Please ask for: Ms Iqraa Malik
Email: iqraa.malik@terraquest.co.uk
Telephone: 01212341390
Our Ref: FG/109/20/HH
Your Ref:
Date: 23rd September 2020

Application for Planning Permission for Works or Extension to a Dwelling

Development: Replacement double garage and workshop - Resubmission of FG/69/20/HH.
Location: 68 Sea Lane Ferring BN12 5EP

SITE PLAN 1:500

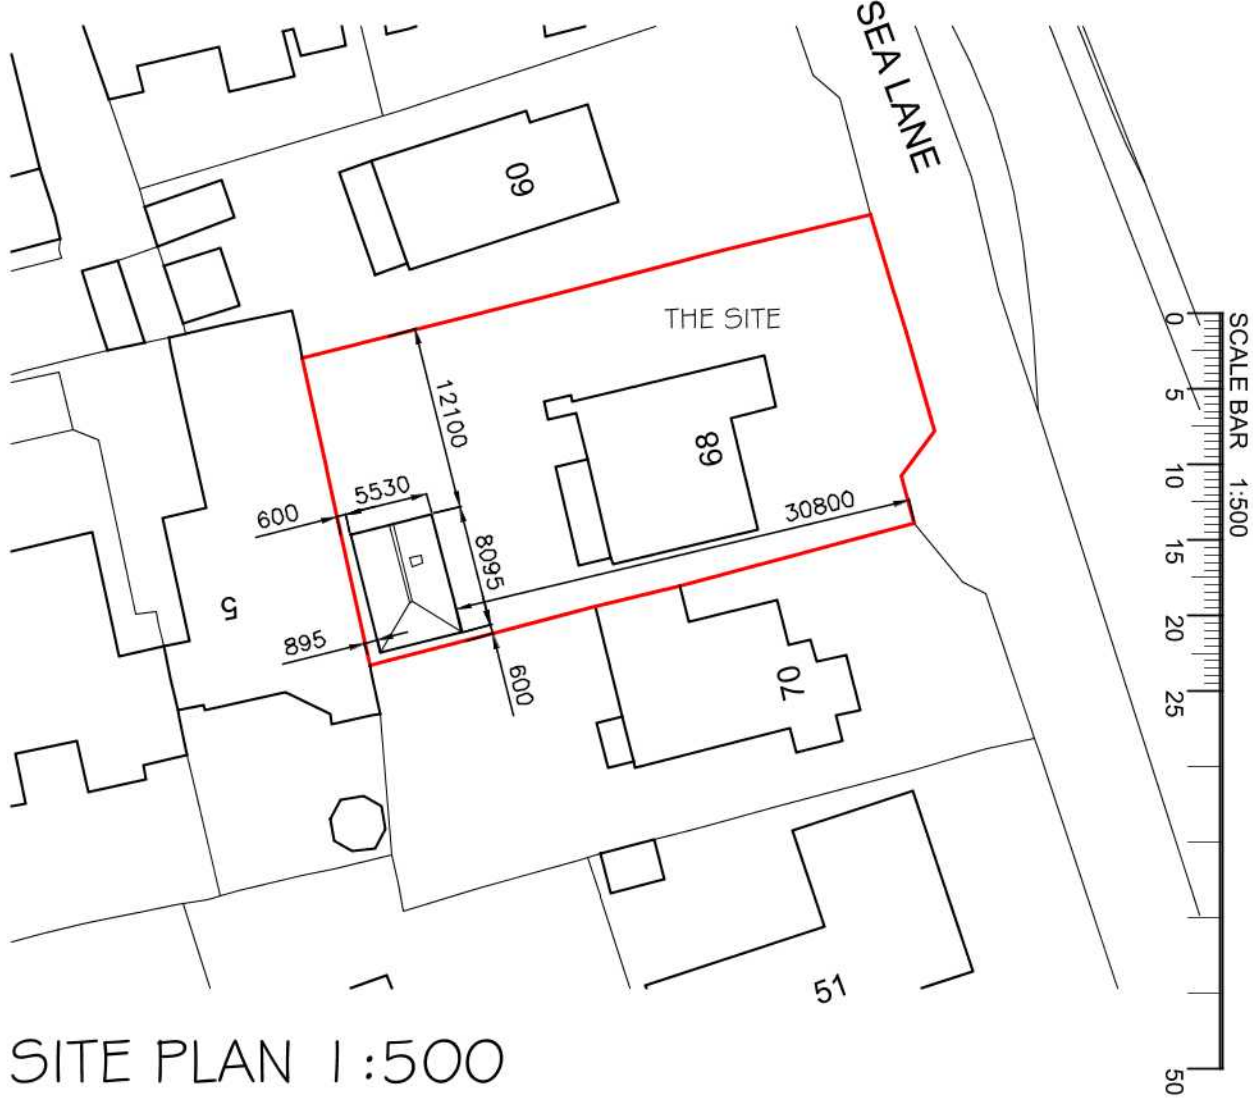
The block plan submitted in drawing PL02C doesn't have an individual scale and the dimensions don't measure to the scale listed for the drawing 1:100. Please amend.
